# Agency Review Comments

South 85/87 Minor Subdivision

EA20100

MS212

FINAL PLAT  
BRADLEY POINT FILING NO. 1  
JOB NO. 70-074  
DATE PREPARED: 01/29/2021  
DATE REVISED: 08/22/2023

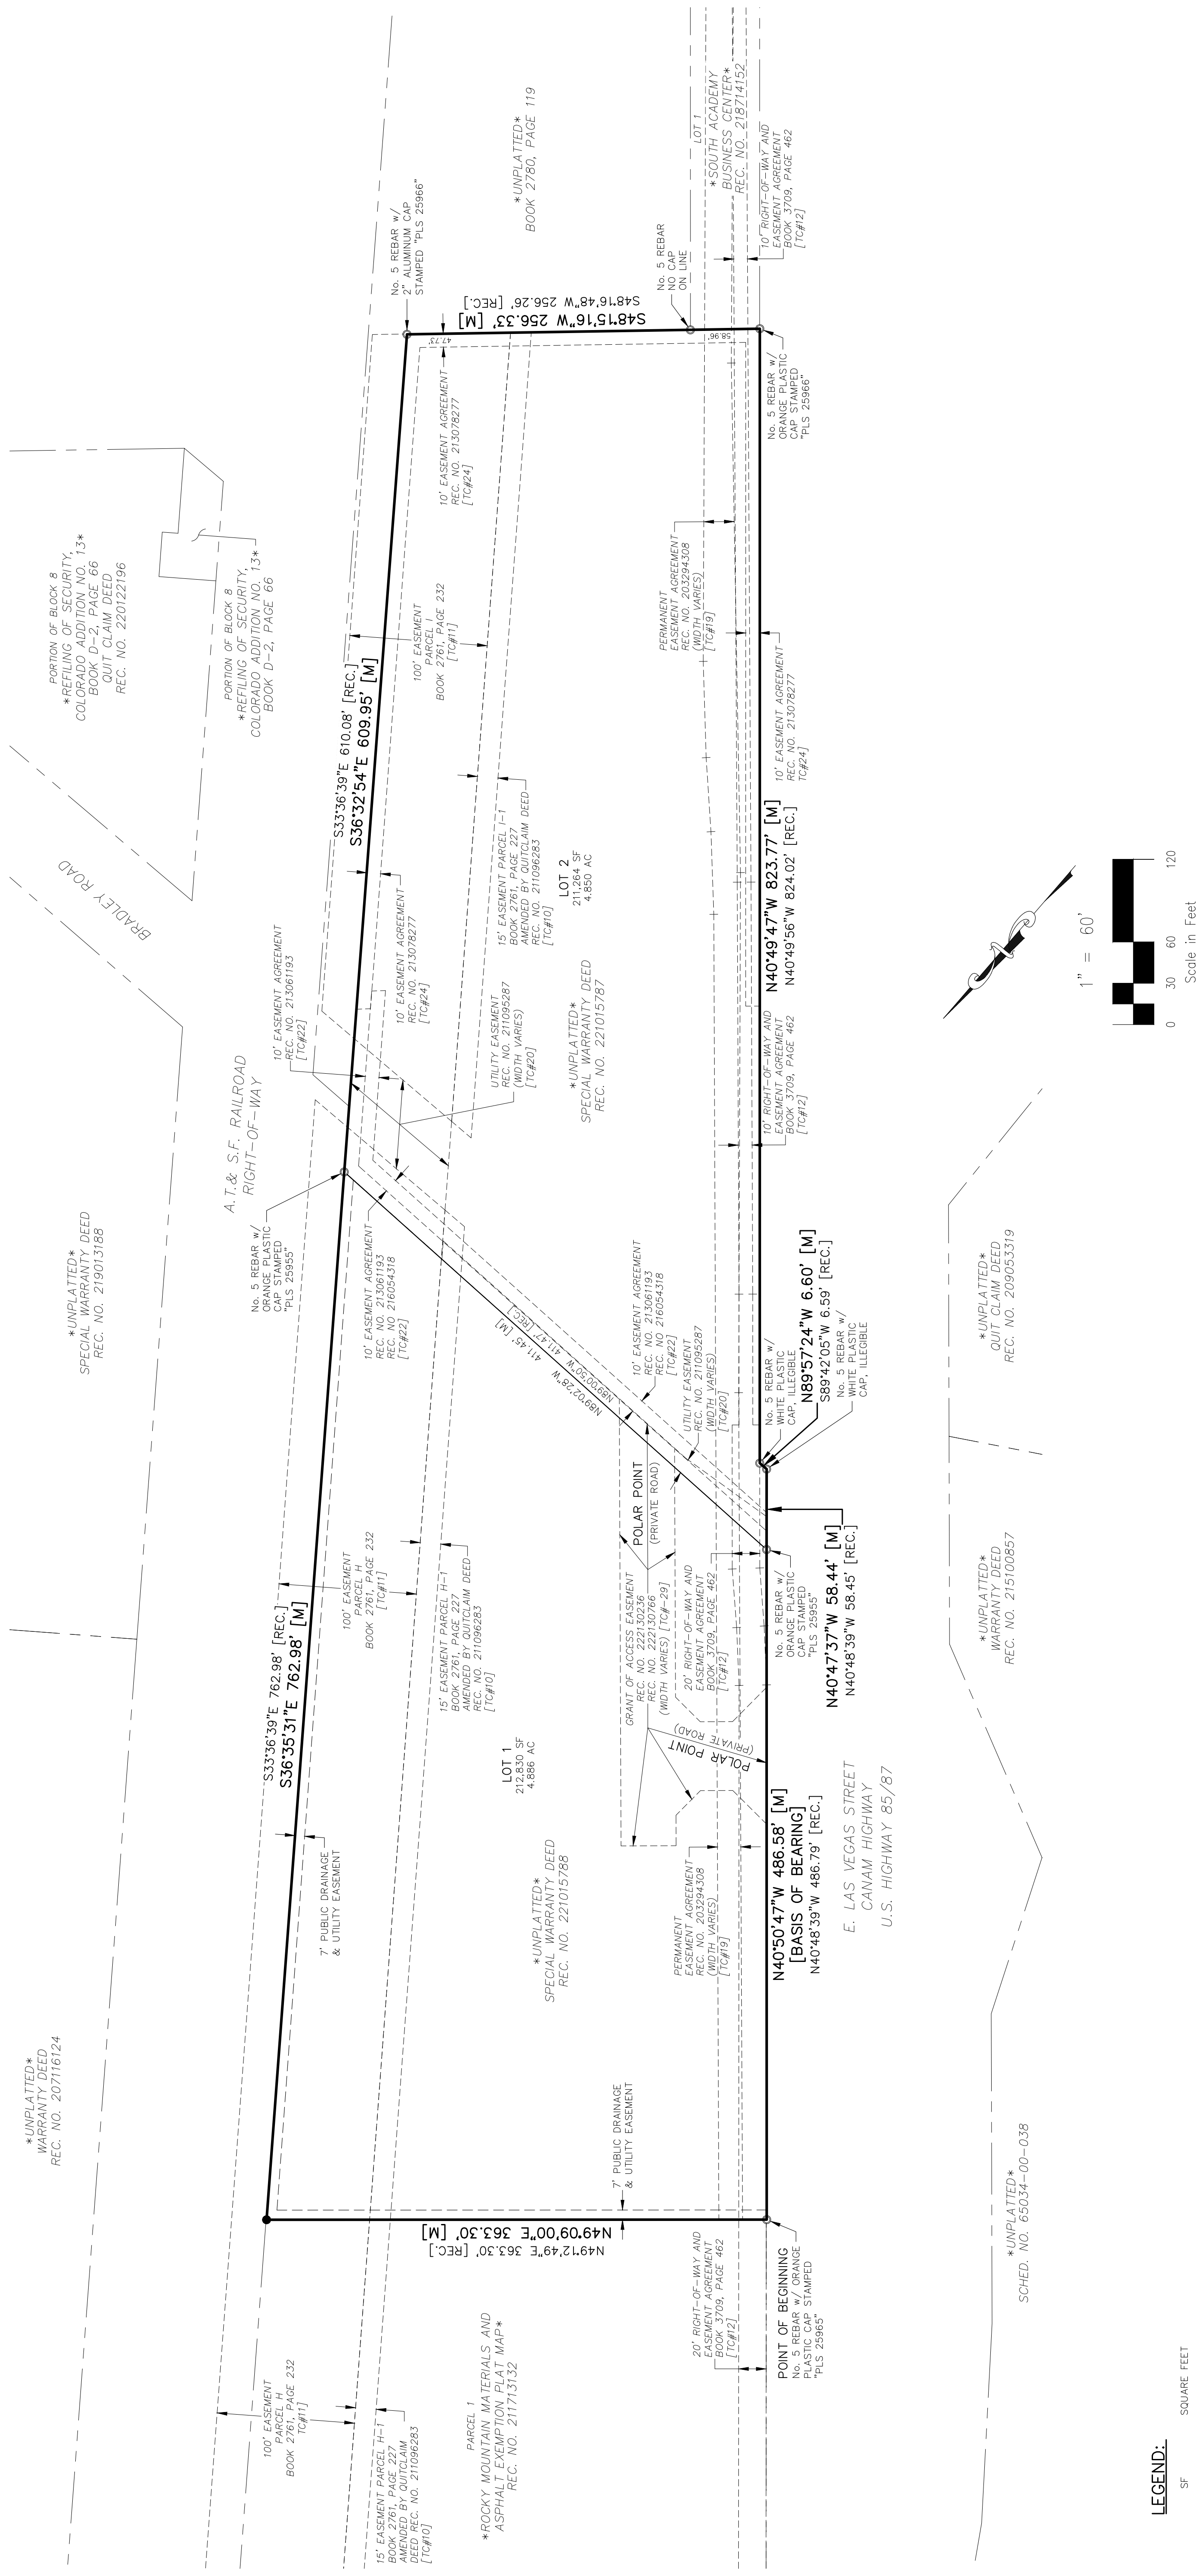
Pikes Peak Regional Building Department	<p>Regarding a request for approval of a final plat for Bradley Point Filing No. 1, Enumerations has the following comments:</p> <ol style="list-style-type: none"> <li>1. The plat does not indicate whether or not there will direct access allowed from Hwy 85/87. Is there direct access or will the cul-de-sac shaped access easement become a paved private street to access each parcel? If this access easement is to function as a street, then Enumerations feels that it should be named.</li> <li>2. Once the question of access has been answered, please submit a copy of this plat to Enumerations to have addresses assigned.</li> <li>3. Prior to recording, Enumerations will review the plat for addressing, street names, title block, and floodplain statement. An Enumerations fee of \$10 per lot addressed will be due at that time.</li> <li>4. Provide a copy of the final recorded plat to Enumerations for our records.</li> </ol>	3/23/2021 10:12:22 AM

**ADDRESSED**

Brent Johnson                    **SEND COPY OF PLAT TO ENUMERATIONS ONCE APPROVED**  
Enumerations Plans Examiner  
Pikes Peak Regional Building Department  
O: 719-327-2888 E: brent@pprbd.org W: pprbd.org
